Please upload the amended drainage plans attached to this email onto Ocella for **LU/90/20/DOC** for Parcels A2 and B6 at Hampton Park.

Comments;

Paul Cann
Principal Engineer (Drainage)

Hydro-Brake Control Chamber HB2

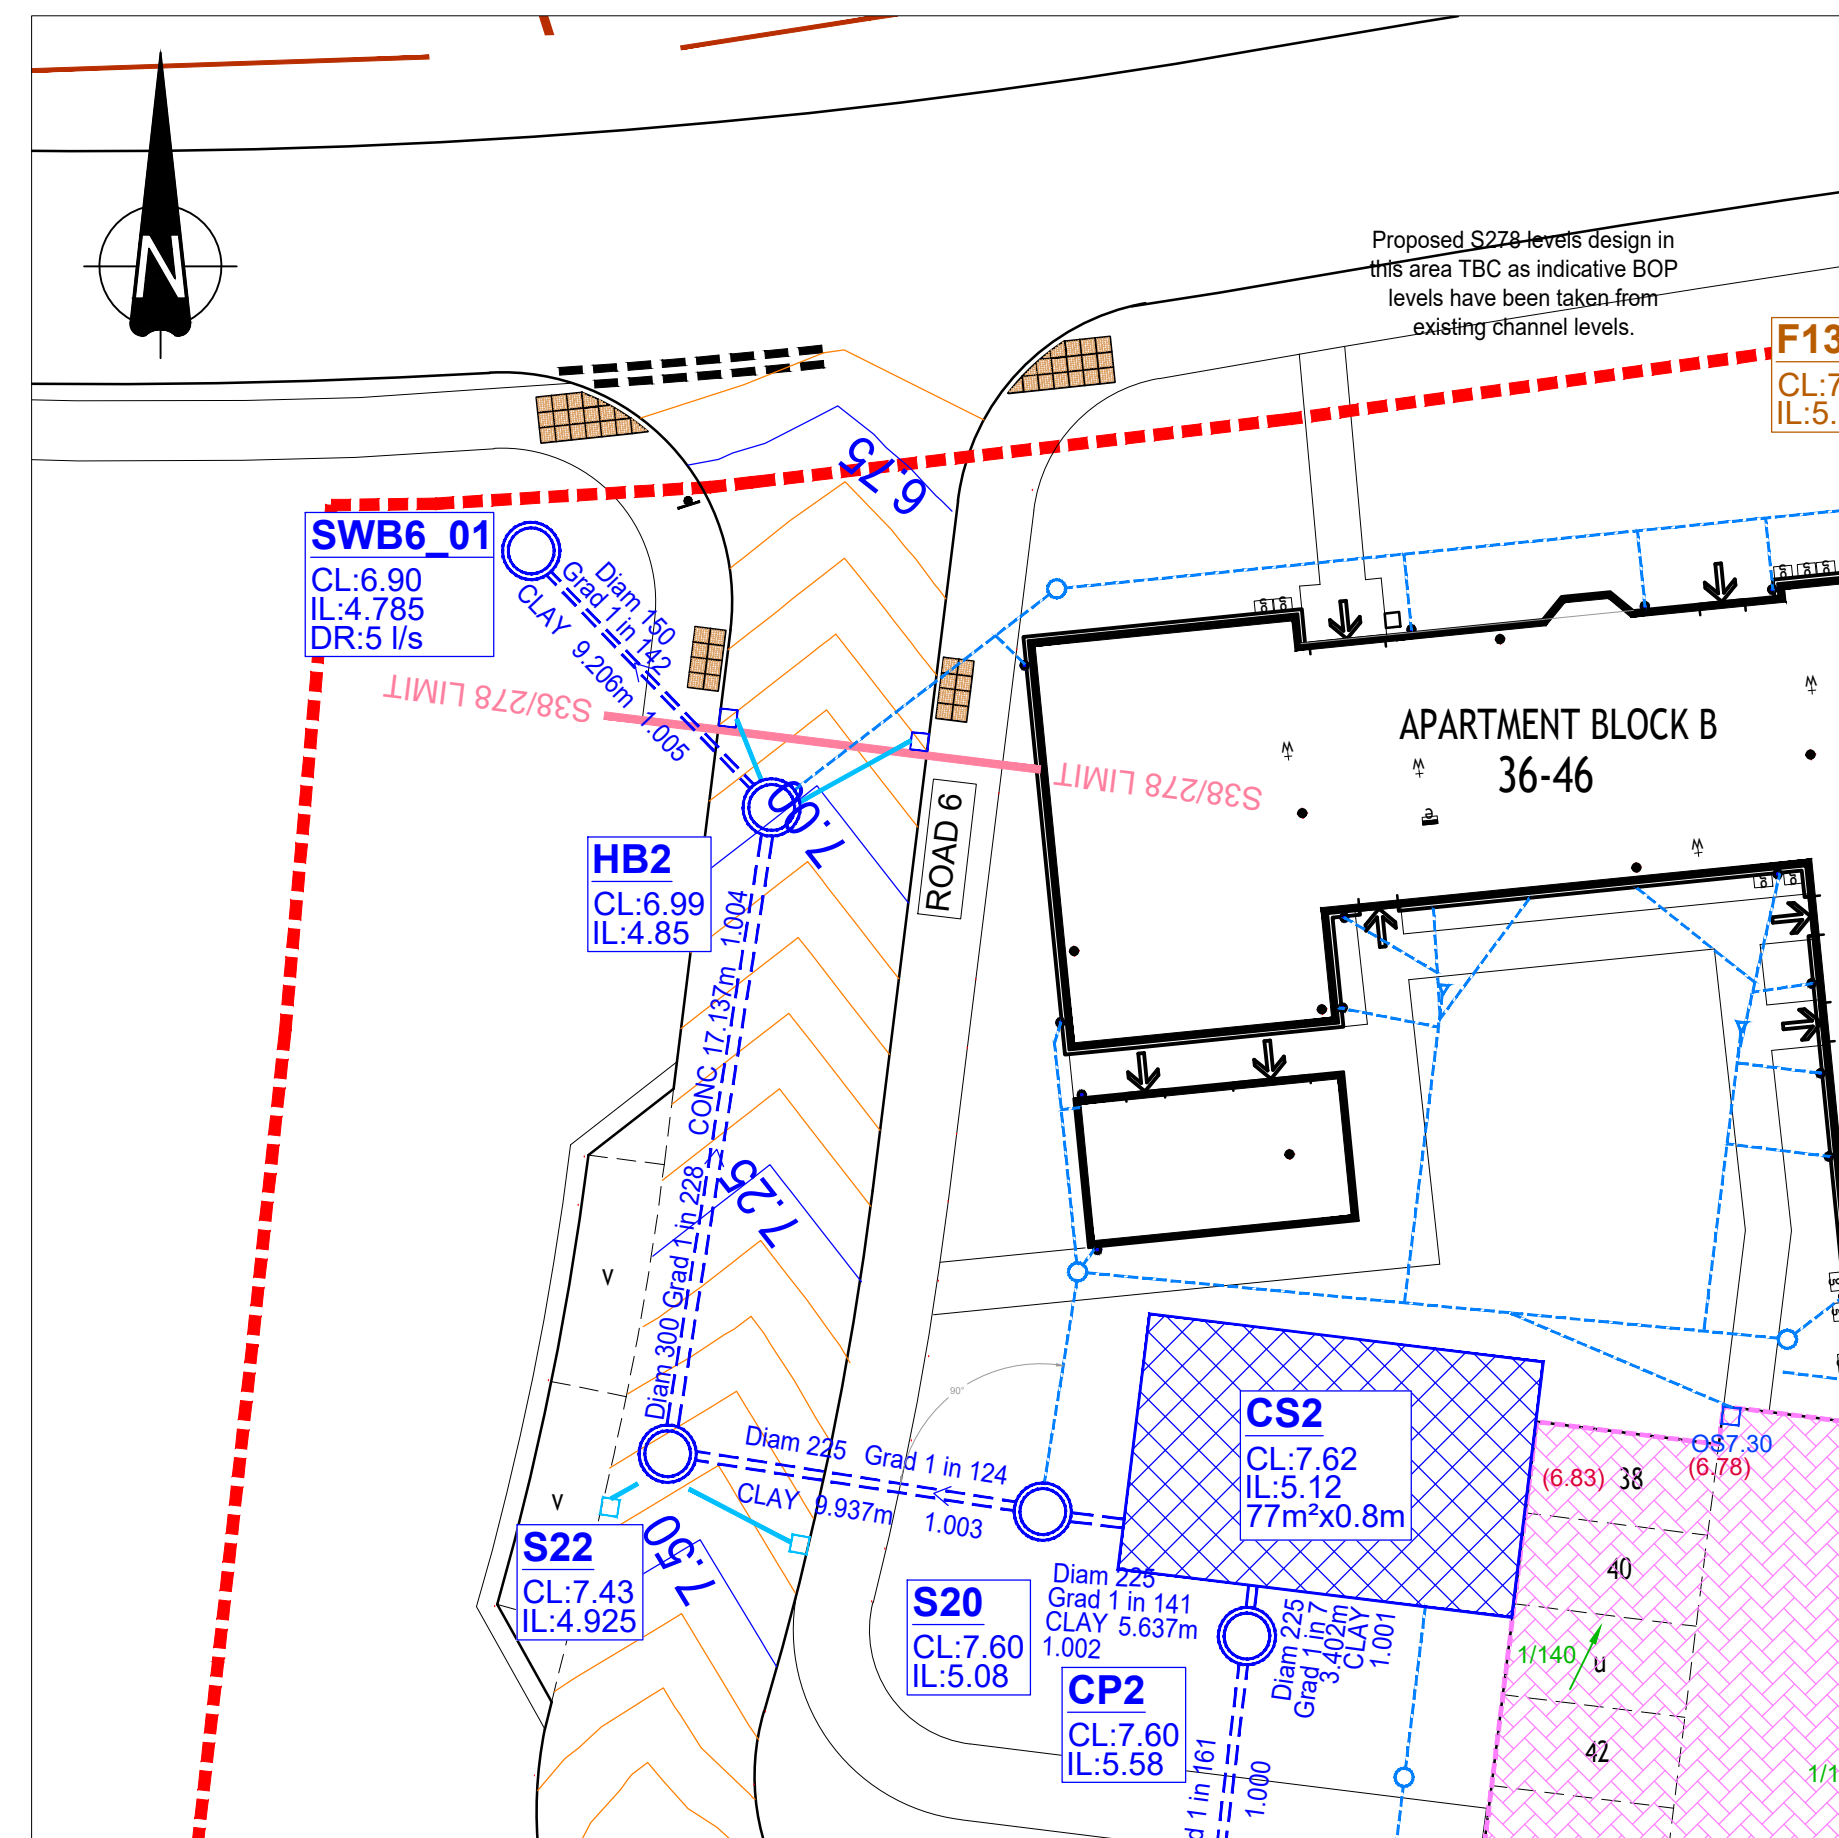
5. Hydrobrake chamber HB02 construction detail – plan view shows incoming 900mm pipe as opposed to 300mm and 1.8m dia rings as opposed to 1.5 dia. Incoming 150mm connections to connect soffit to soffit with 300mm pipe. The gully that is connecting against flow and above hydrobrake is not ideal but willing to accept it in this instance (Section A-A shows it in a different location to the plan view?)

6. Both hydrobrake chambers – show base thickness/reinforcement details.
7. Existing manhole SW03A – just upstream of SWA2_01 – what is its purpose? Invert level is lower than the downstream manhole. Please clarify if it is required and adjust as necessary.
